TRAFFIC IMPACT STUDY

**Jaynes Property
El Paso County, Colorado**
PCD File No. SKP225

November 2022

## SKETCH PLAN

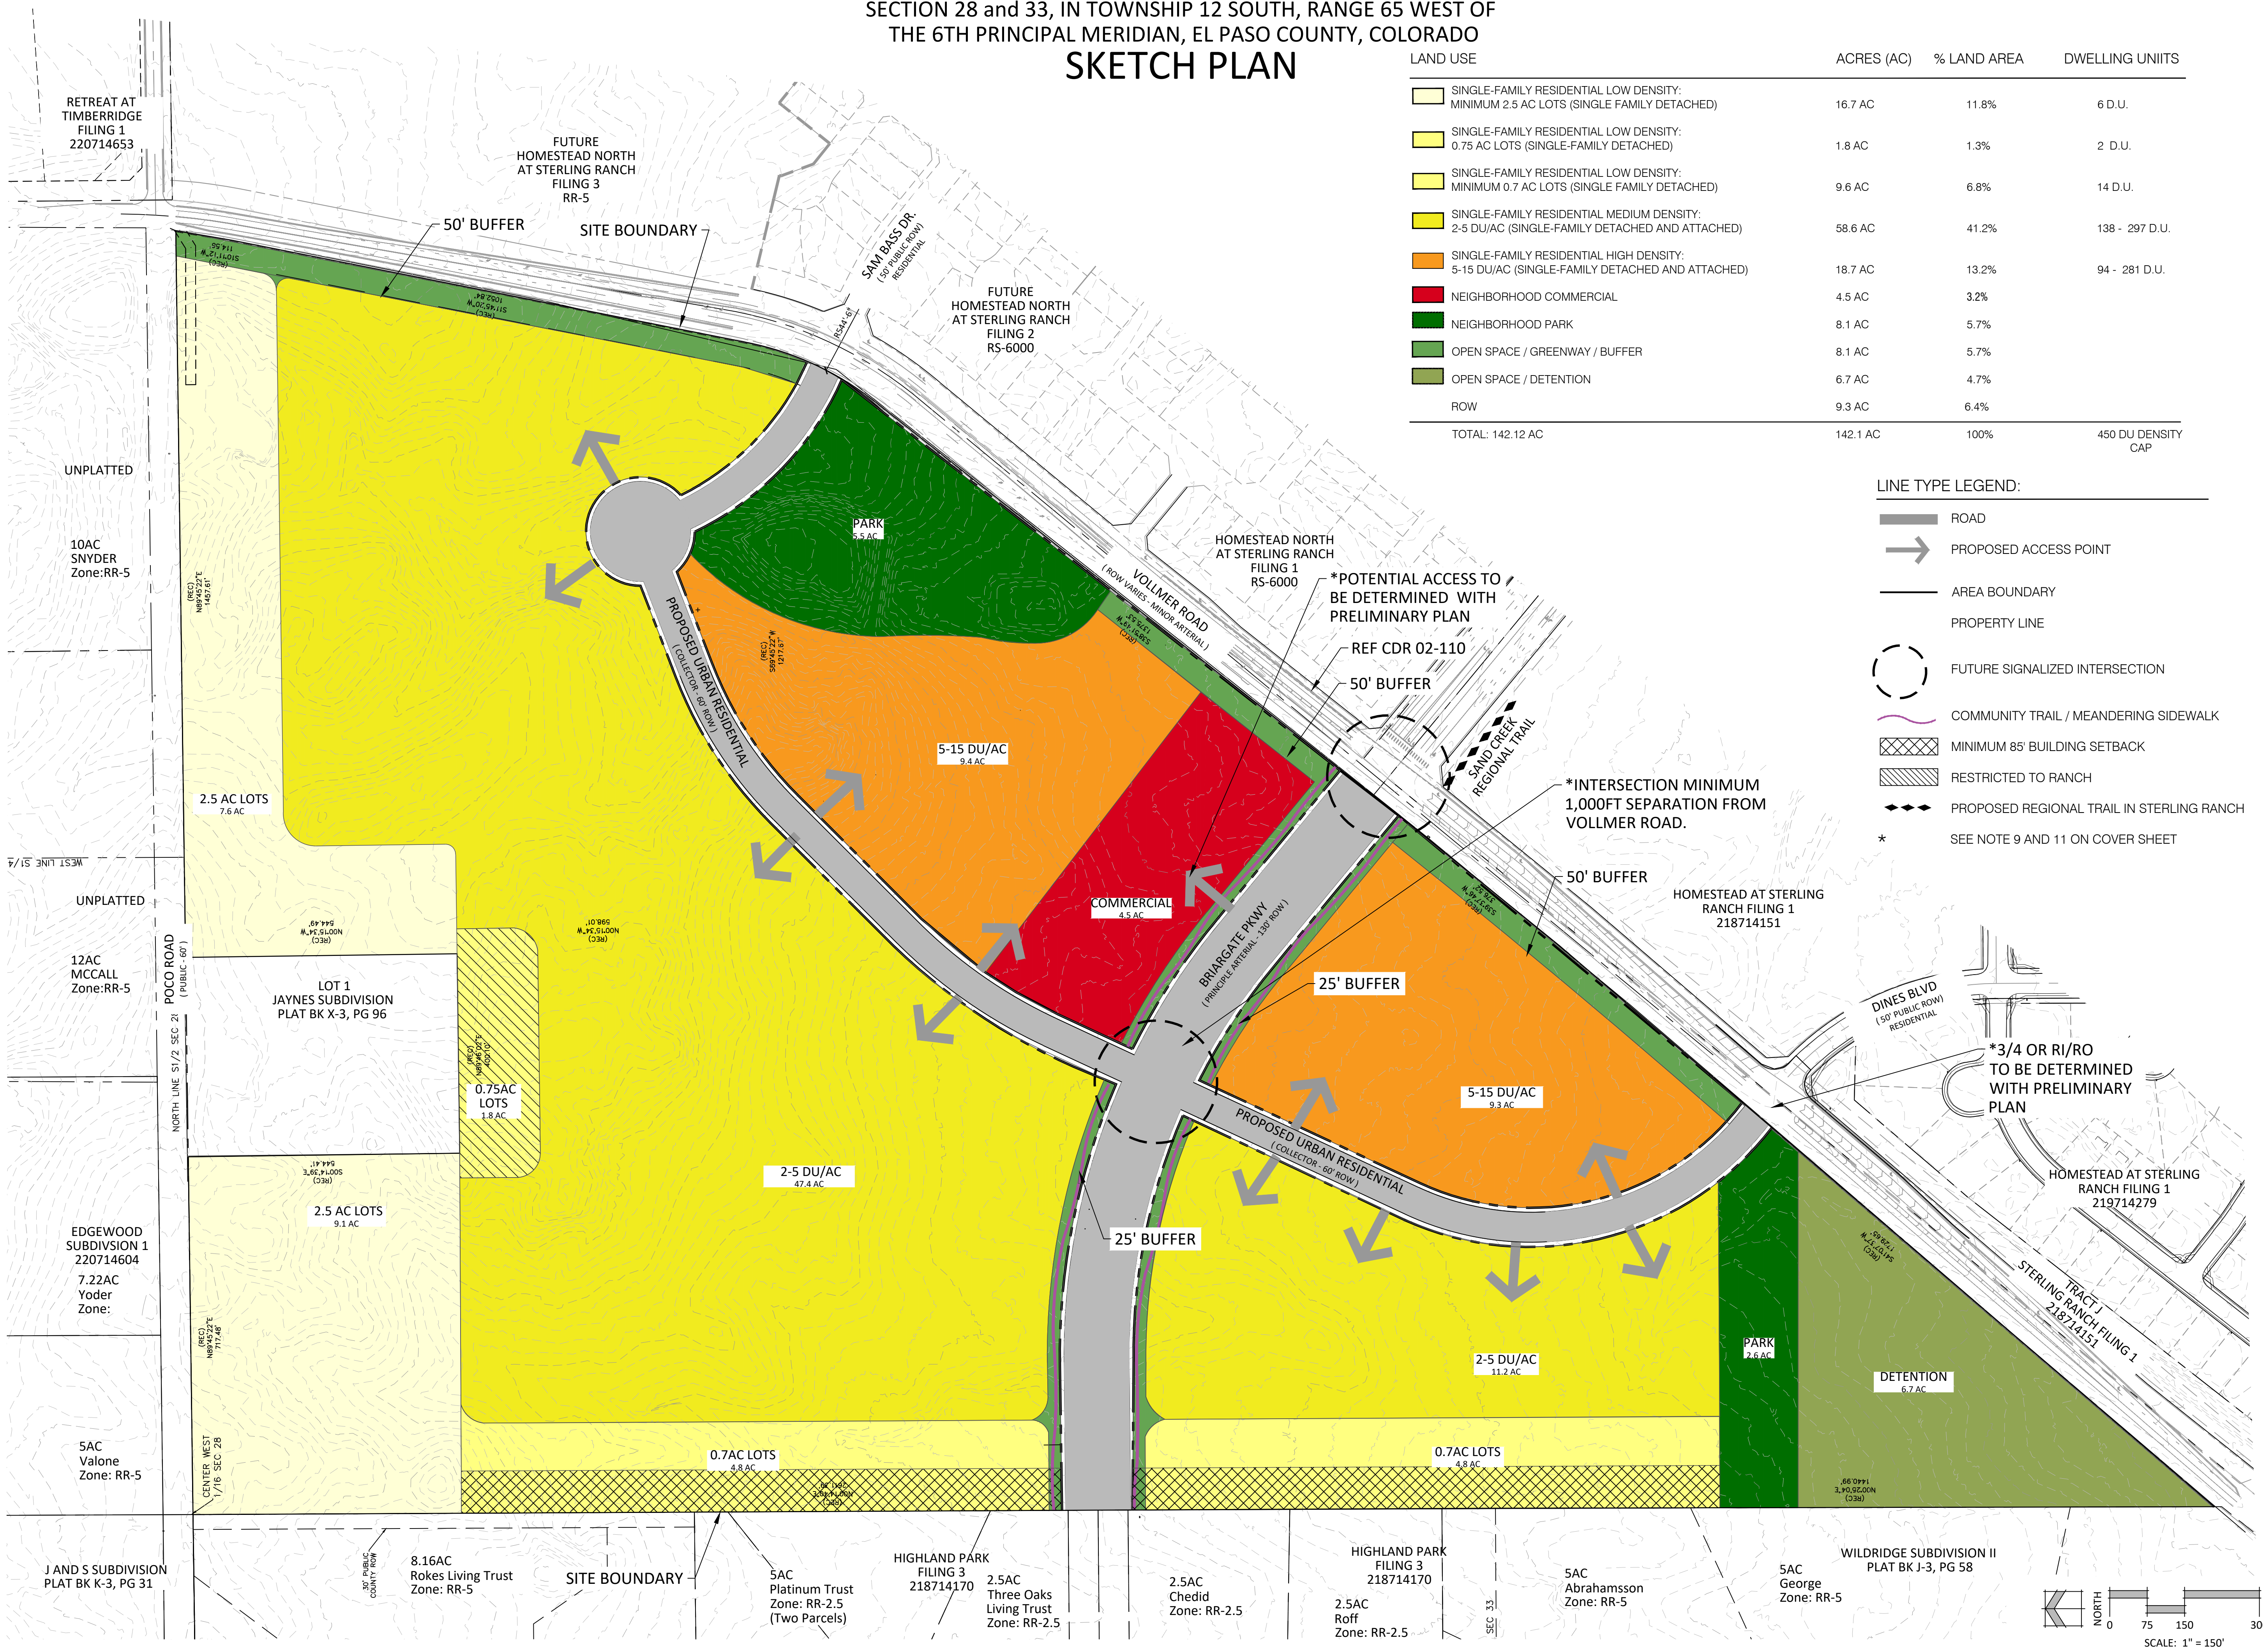
Clarify - full movement
is unlikely here;
possibly RI/RO or 3/4
only because of vertical
alignment on east side.

We understand that a sketch plan is conceptual, but the location of this intersection will reduce the chances of any additional access being granted between here and Vollmer Road. The intersection should be approximately 400-500 feet from the west property line on the ridge, at least 1,000 feet to Vollmer Road.

Comment acknowledged.
Access conditions to be
determined with Preliminary
Plan.

Comment acknowledged.
Access conditions to be
determined with Preliminary
Plan.
